Ribble Valley Borough Council
Housing & Development Control

Application no: **3/2023/0384**

Address: **Honfleur 3 Grindleton View Chatburn BB7 4BE**

Proposal: **Proposed new 4 bedroom dwelling and creation of new access on land to the side of 3 Grindleton View.**

Proposed Visibility Splay Plan
Scale (1 : 500)

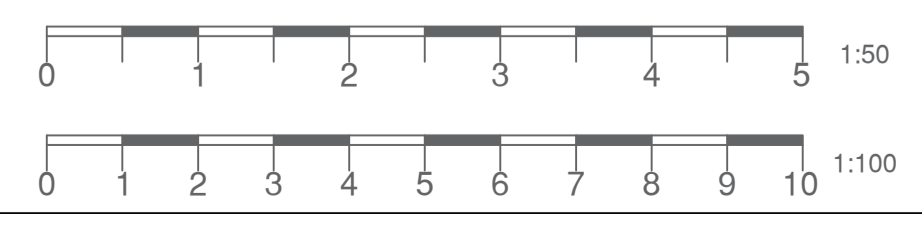
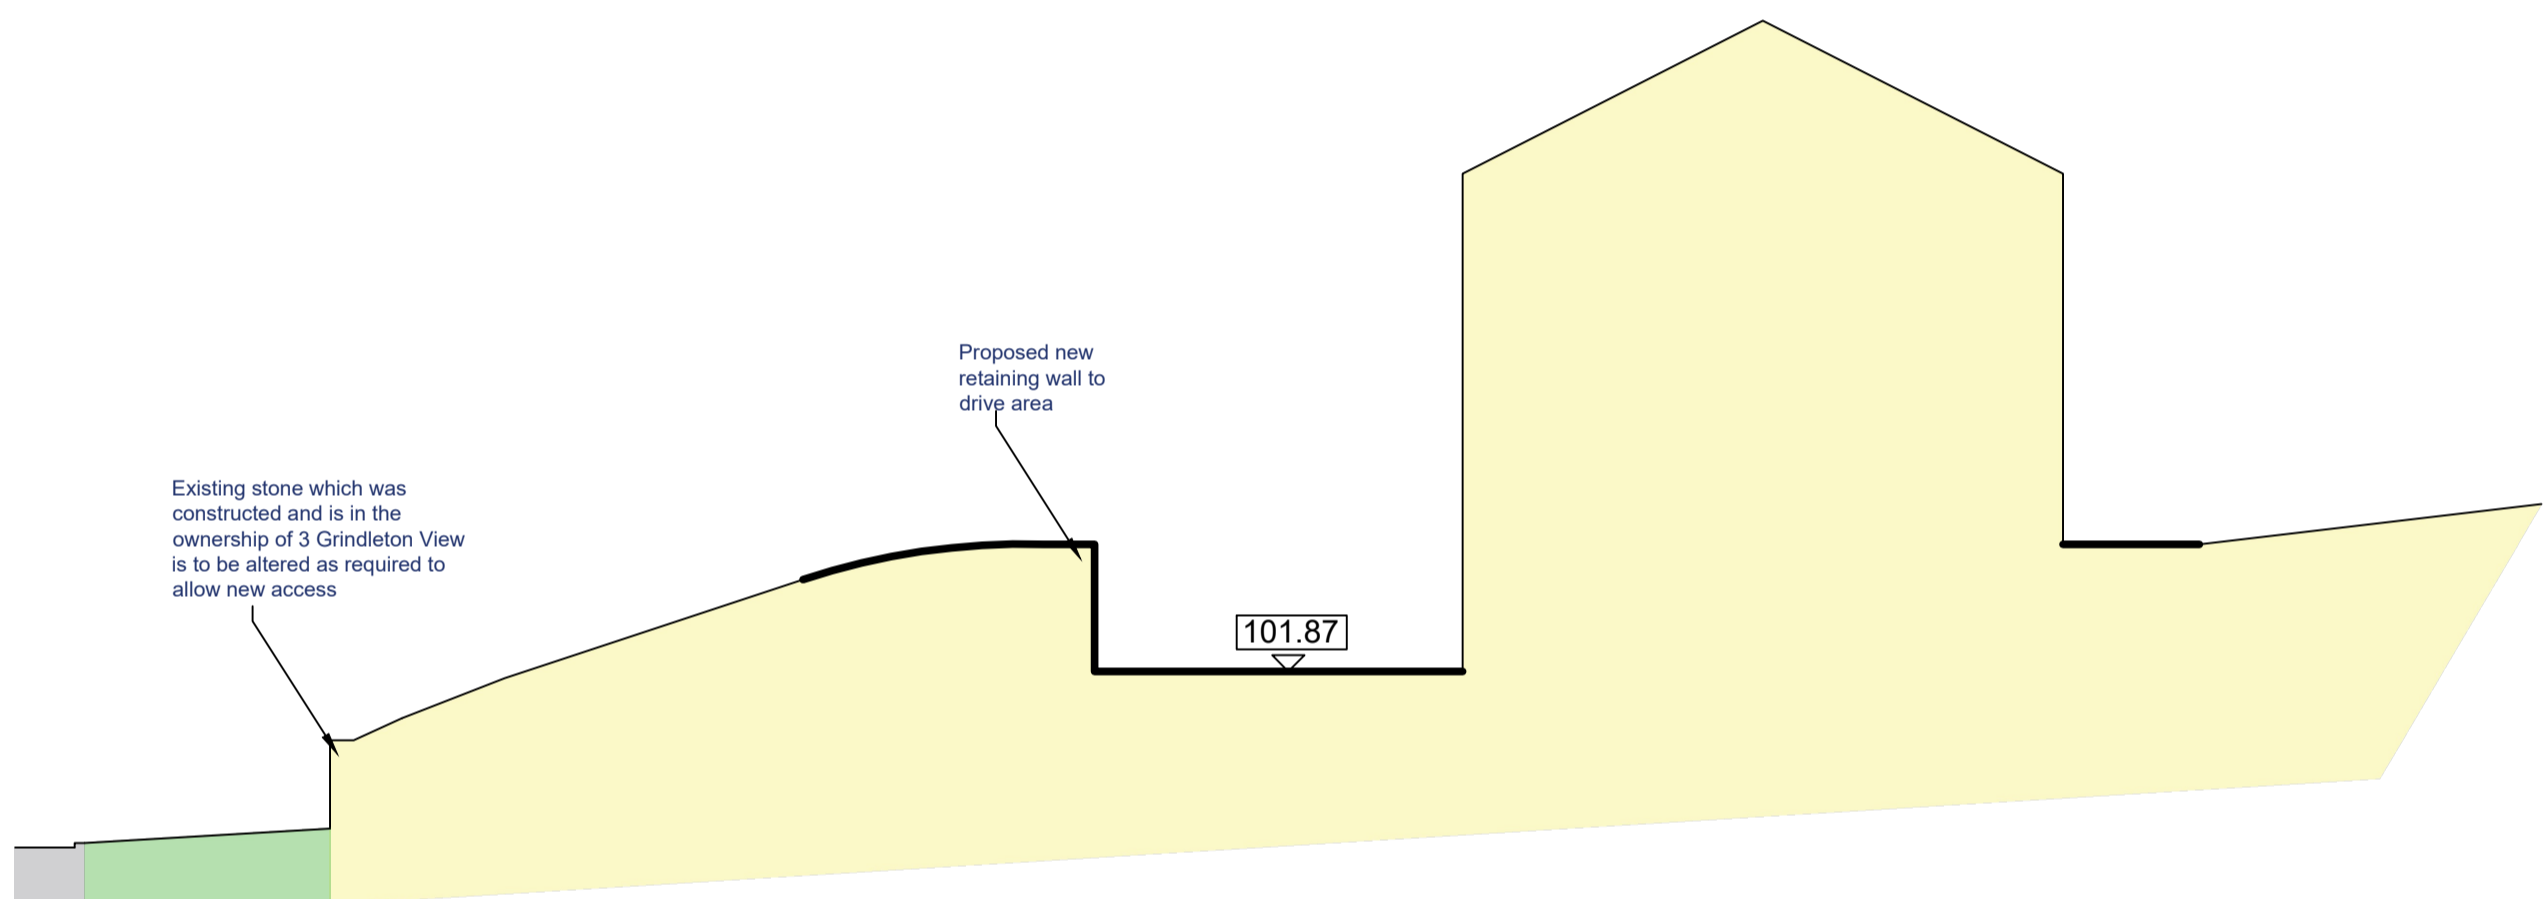
The LHA have reviewed Holden drawing number 004 Rev A titled "Proposed Plan" which shows that the access can provide splays of 102m in both directions. However, the visibility splays are not drawn correctly. This is because firstly, the setback distance of the visibility splays are not drawn 2m behind the highway boundary. Instead, they are setback approximately 3.9m.

The splays provided to the south and to the north of the access are also not drawn correctly. This is because the splays are not drawn to the highway verge edge, with the splays to the south drawn to a 3m offset into the carriageway. Therefore, to ensure that the setback distance and the splays to the north and south are drawn correctly, a revised visibility splay drawing is required.

Proposed Visibility Splay Plan
Scale (1 : 5 0 0)

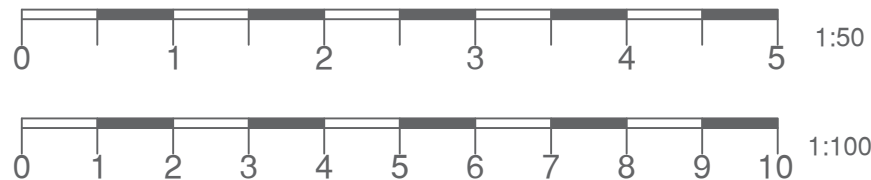
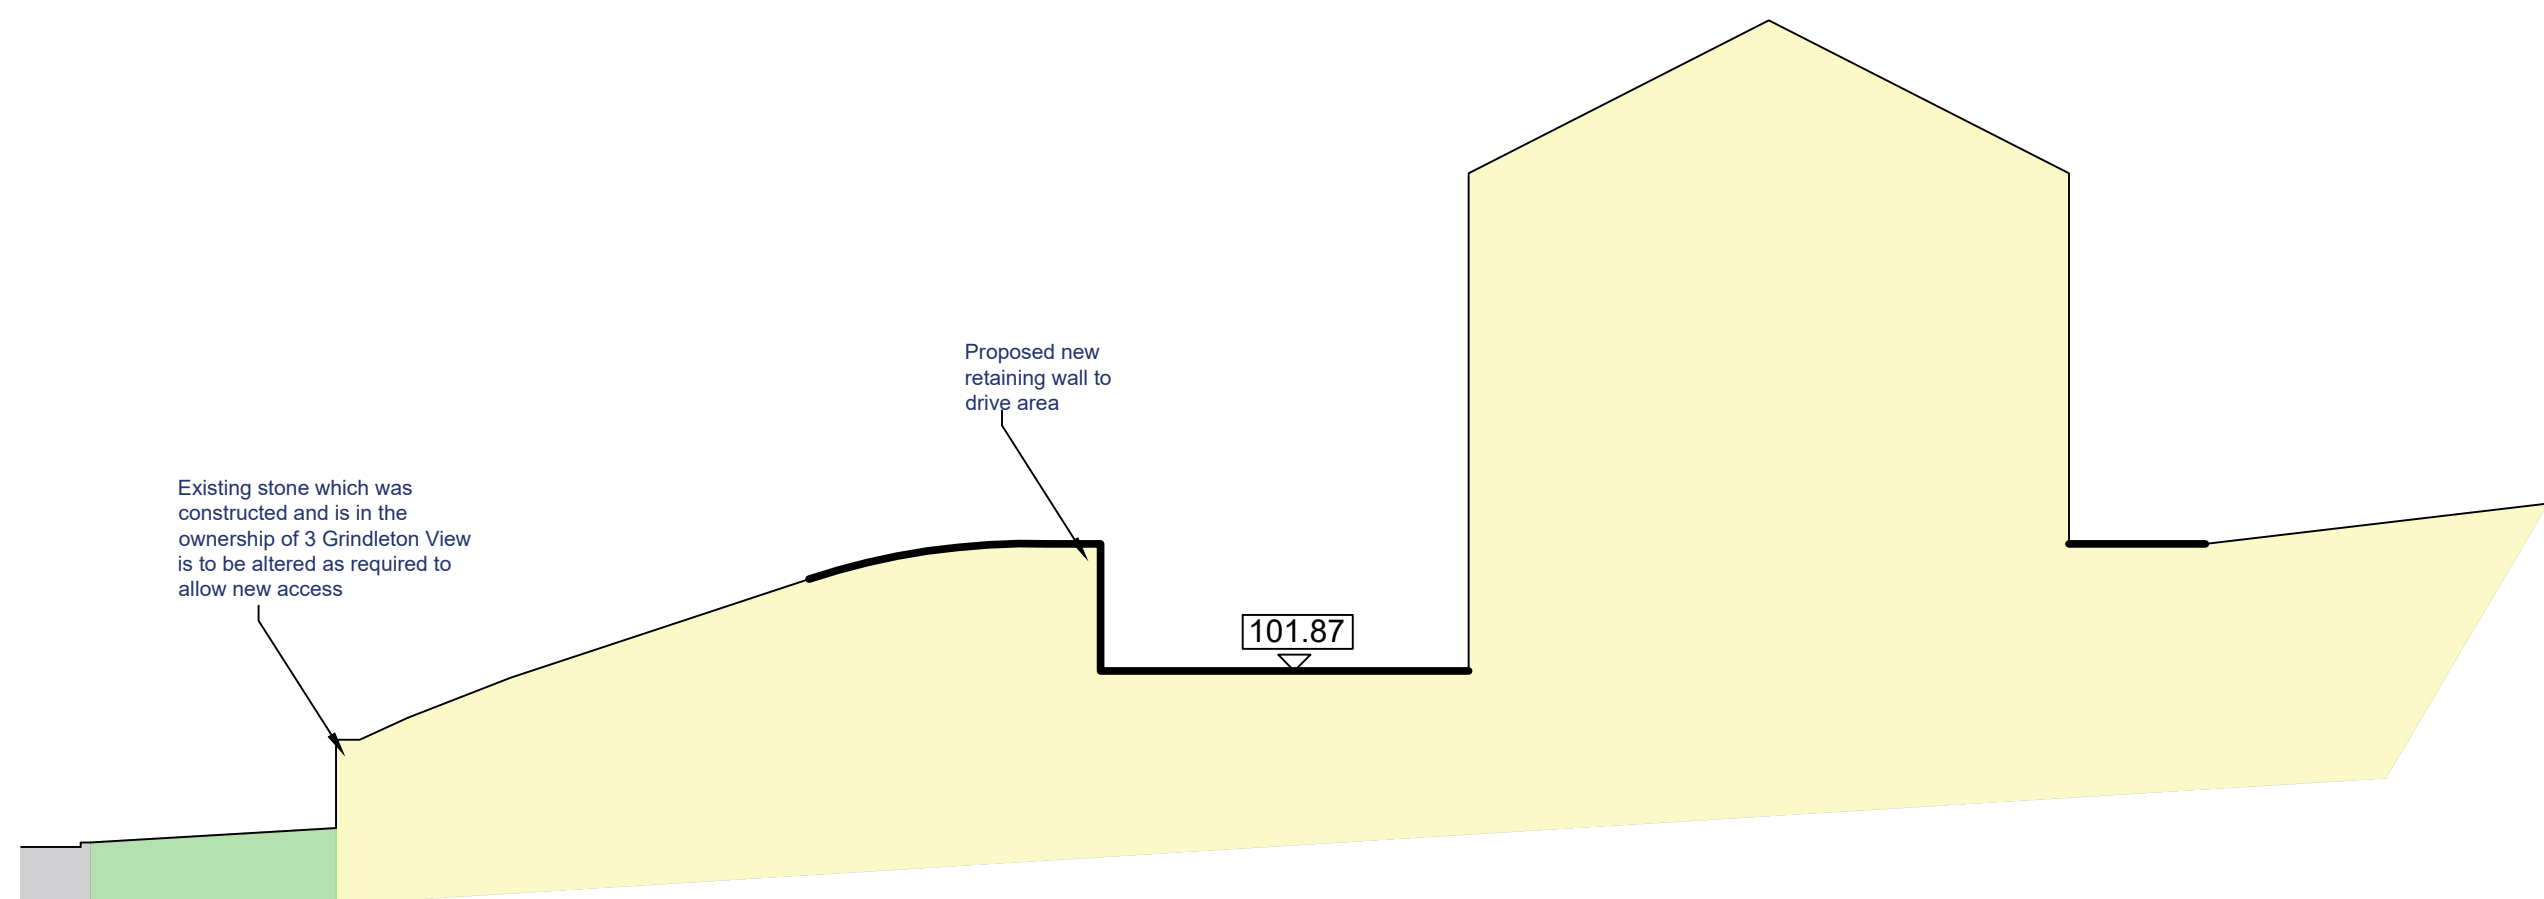
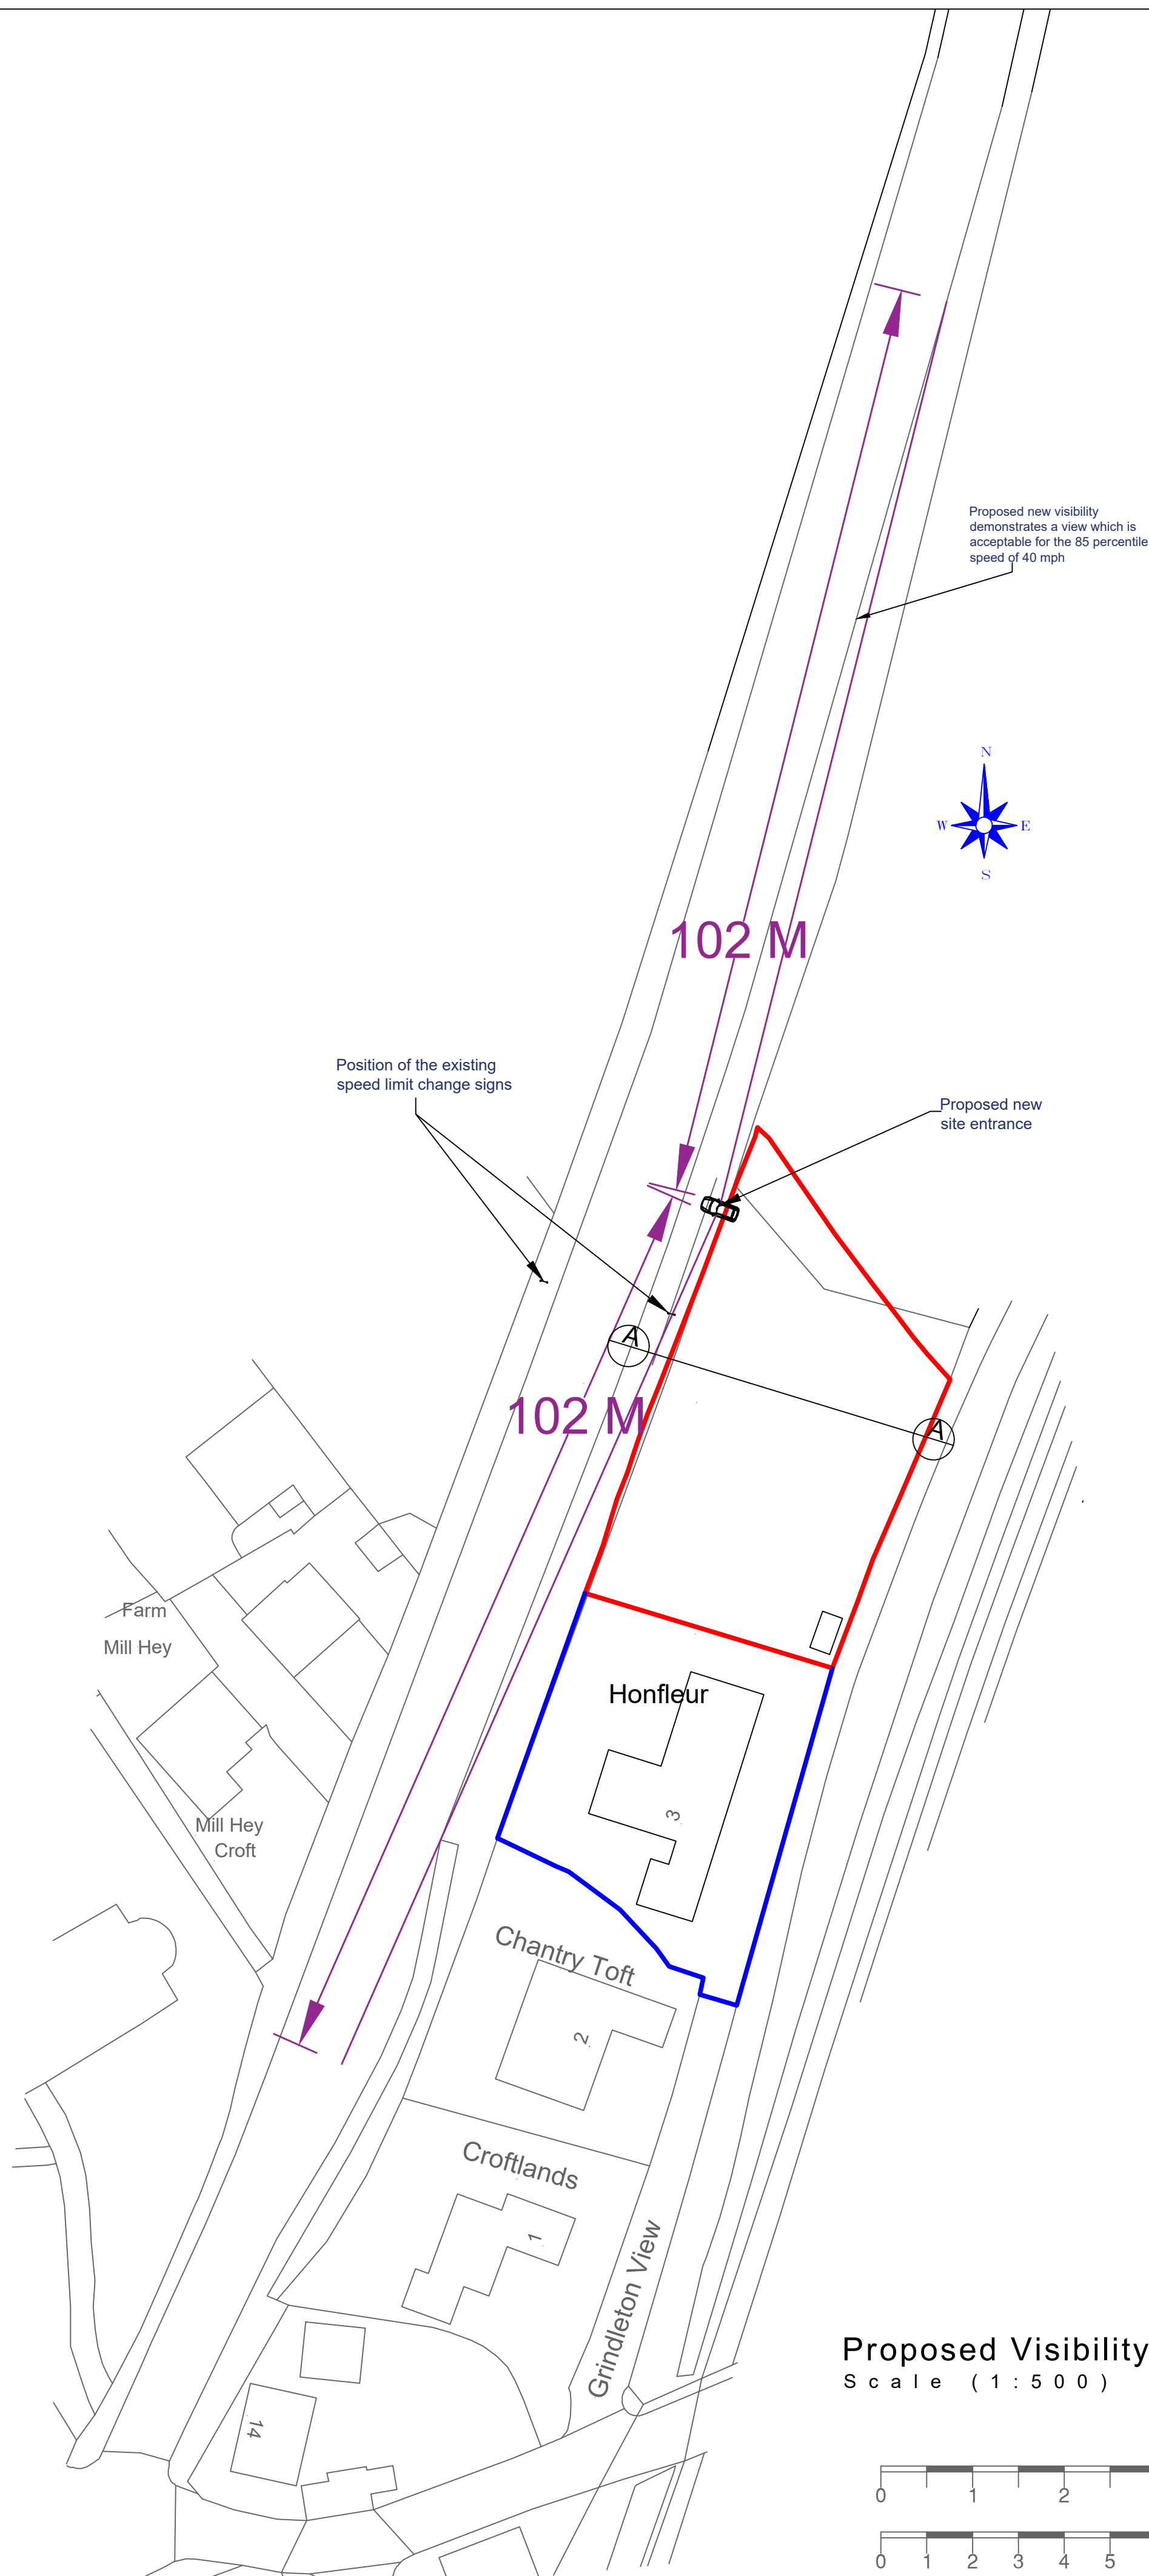
The LHA have reviewed Holden drawing number 004 Rev A titled "Proposed Plan" and note that a new site access will be provided off Sawley Road. However, the LHA require a revised drawing to be submitted showing the width of the access, with no defined site access being shown on the revised plan.

The LHA also makes the Developer aware that should the application be permitted the creation of the access will be subject to a Section 278 agreement. As part of the agreement, the existing highway verge located at the back of the carriageway, will become part of the driveway, connecting the dwelling to the adopted highway. As a result of this, the LHA require the grass verge to be removed from the drive section and be labelled as driveway.

Should the revised visibility splays conflict with any street furniture including traffic signs, the LHA will require that they are located out of the splays and relocated further into the highway verge. These works will be undertaken under a Section 278 agreement.

The LHA have further reviewed the drawing which provides a drive section and are aware that the gradient of the access will be approximately 1 in 11.43. While this does exceed the maximum gradient which is accepted within the Inclusive Mobility document, the LHA do note that the development will remain private. Therefore, the LHA will accept the provided gradient.

**Proposed Site Plan**  
 Scale (1:500)

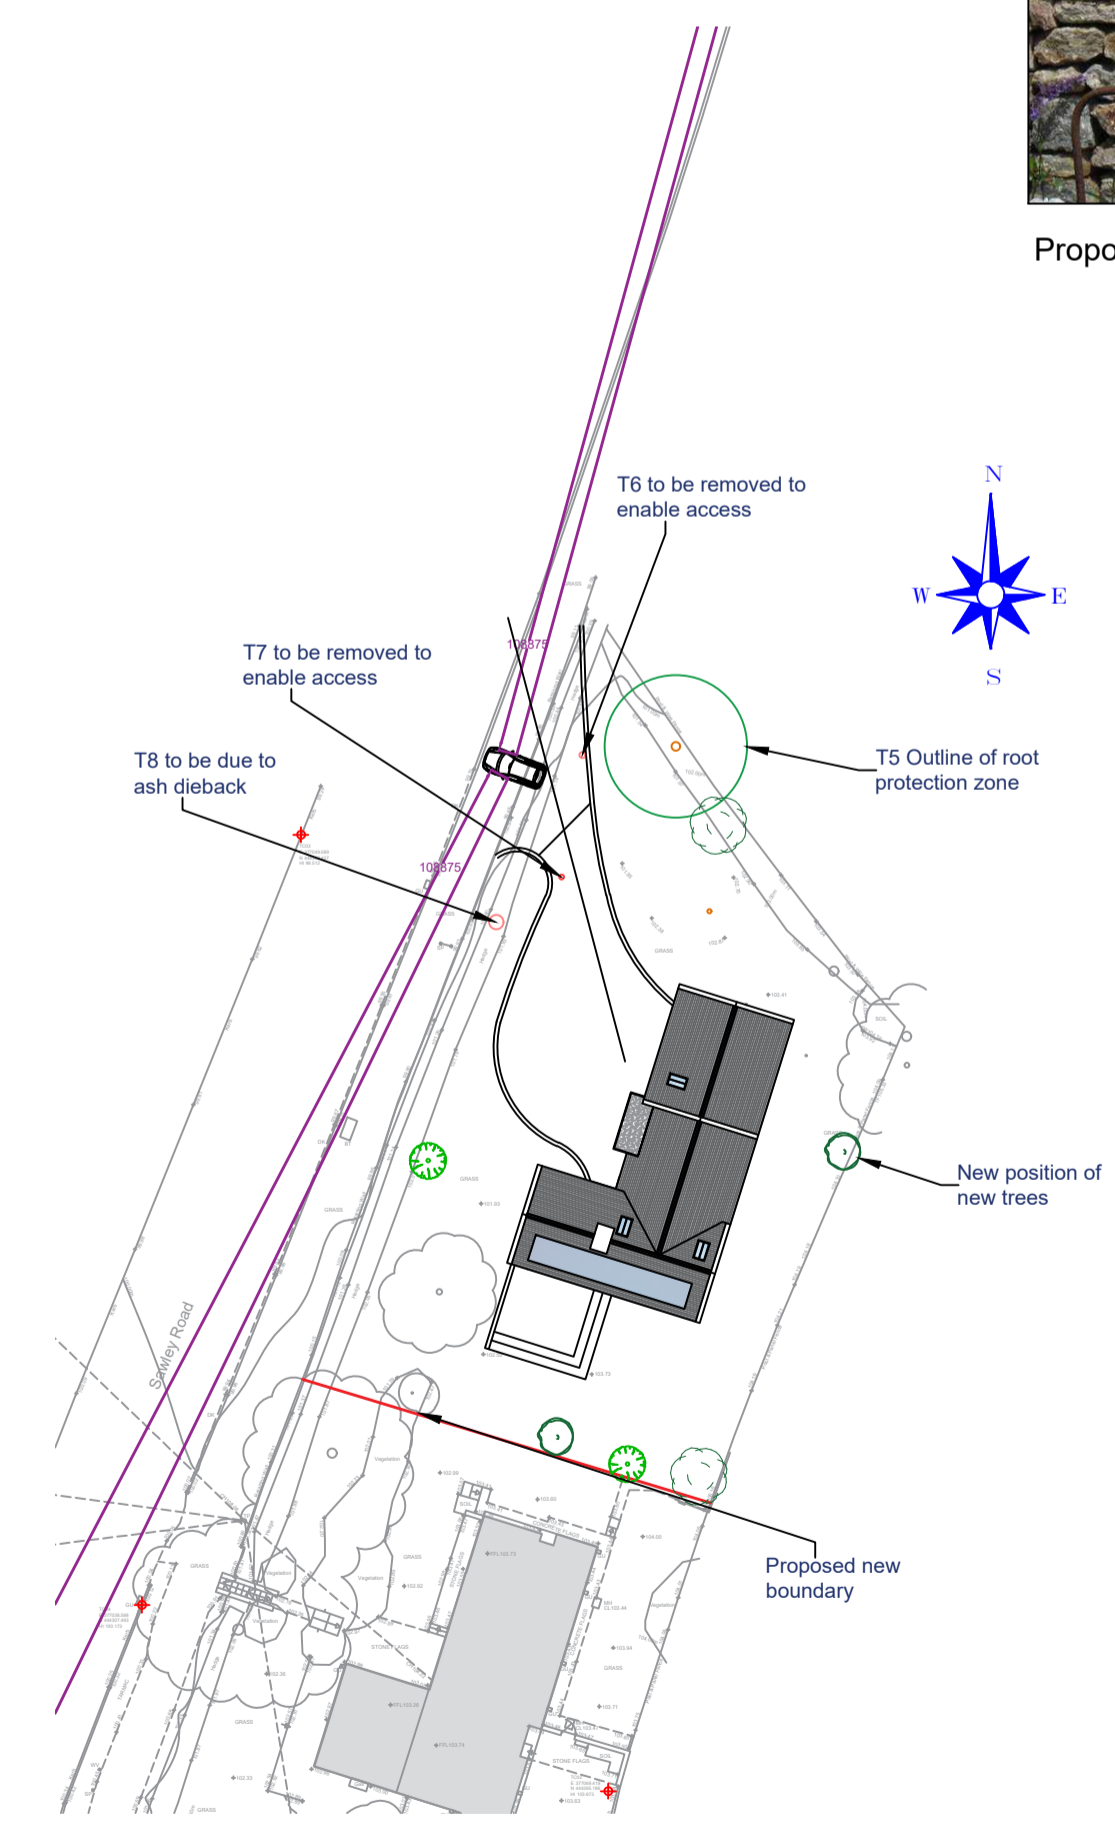
The LHA have reviewed Holden drawing number 003 Rev B titled "Proposed Plan" and are aware that the parking arrangements complies with the LHAs parking guidance as defined within the Joint Lancashire Structure Plan.

The LHA remind the Agent that a minimum of one car parking space will need to have access to an electric vehicle charging point and some form of cycle storage provision for the occupants of the dwelling will need to be provided.
